**Consultation Response from KC,
 Highways Development Management**
2026/91627 Land at, Dunford Road, Hade Edge, Holmfirth, HD9 2RT
Erection of 22 dwellings (Use Class C3) associated development including access, landscaping, ancillary infrastructure, and parking.
Date Responded: 06/08/2026
Responding Officer: Ryan Kinder
Responding Ref: K3-43/6

2026/91627 Land at Dunford Road, Hade Edge.

RECOMMENDATION: Objection – further information required.

Proposed Site Layout - Option A (Site A)

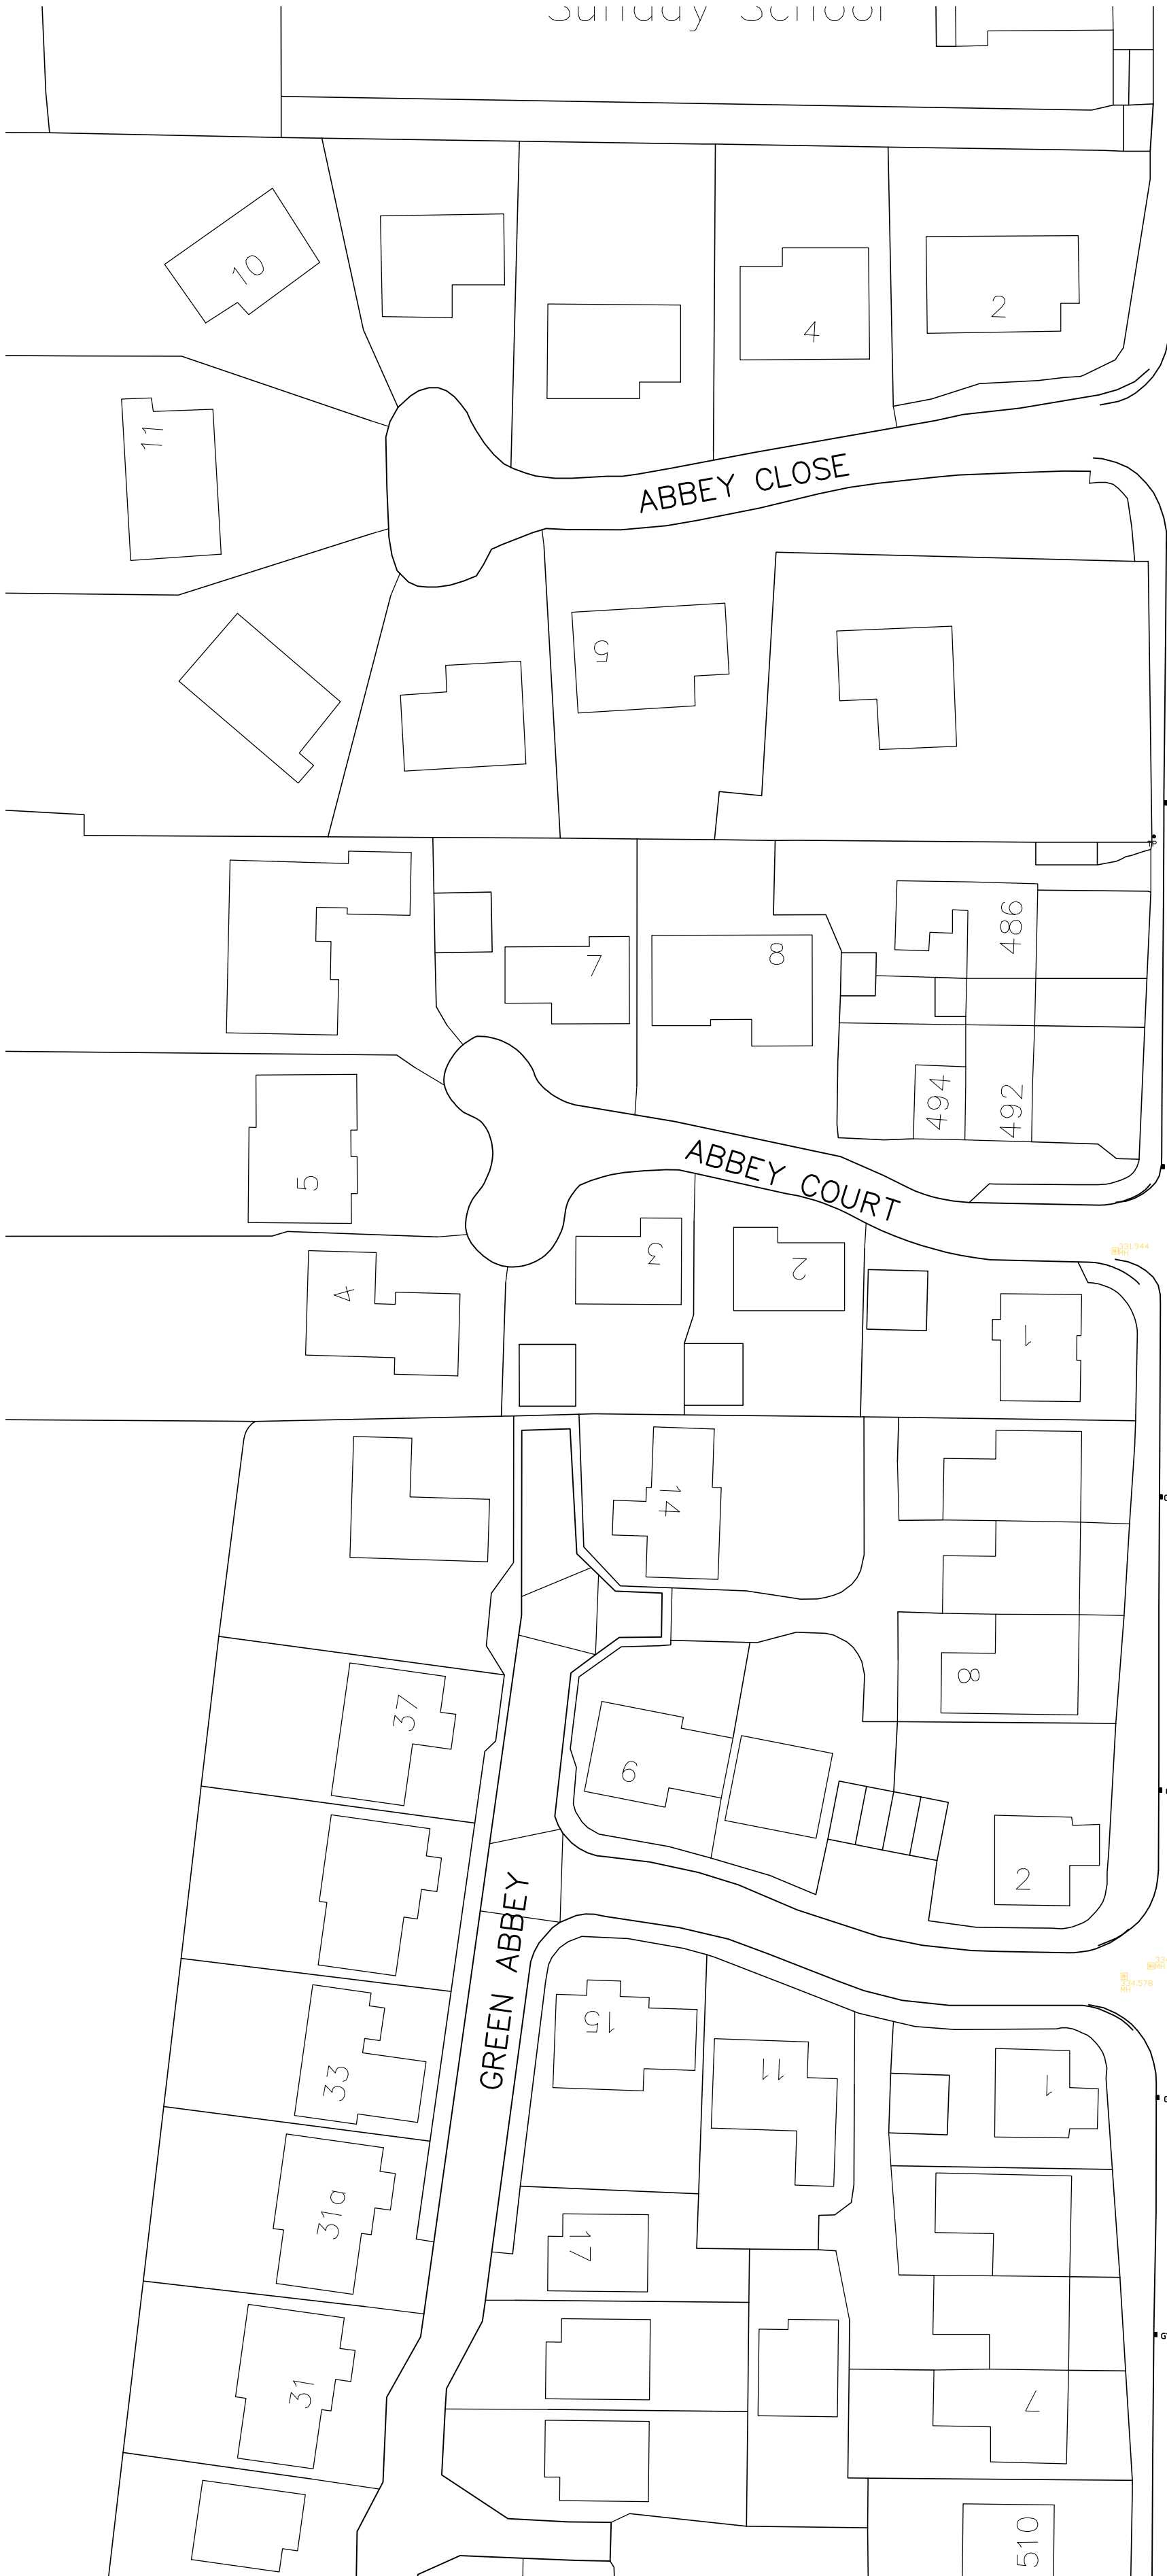
The internal road layout should be designed to adoptable standards and in line with the Councils SPD highway design guide. The current proposal indicates a 'traditional estate road initially then onto a shared surface on the side road and private driveways. There are no long sections or finished gradients indicated on the submissions, for a shared surface arrangement the gradient must not be steeper than 1:20 otherwise a footway down both sides is required. Further clarification on this matter is therefore requested.

Forward visibility envelopes and junction sightlines should be indicated and achievable within the Highway boundary, it appears these are not indicated at the shared surface area of the site.

The proposed parking provision design for some properties appears to fall short of the design requirements. Where no segregated pedestrian access is provided for each property the width of the parking bays should be increased from the standard 2.5m to allow an additional 0.9m width to accommodate pedestrians exiting vehicles and for wheelie bin access.

Visitor parking spaces are indicated, however a minimum of a 1.0m hard margin to the rear of these is required for exiting vehicles.
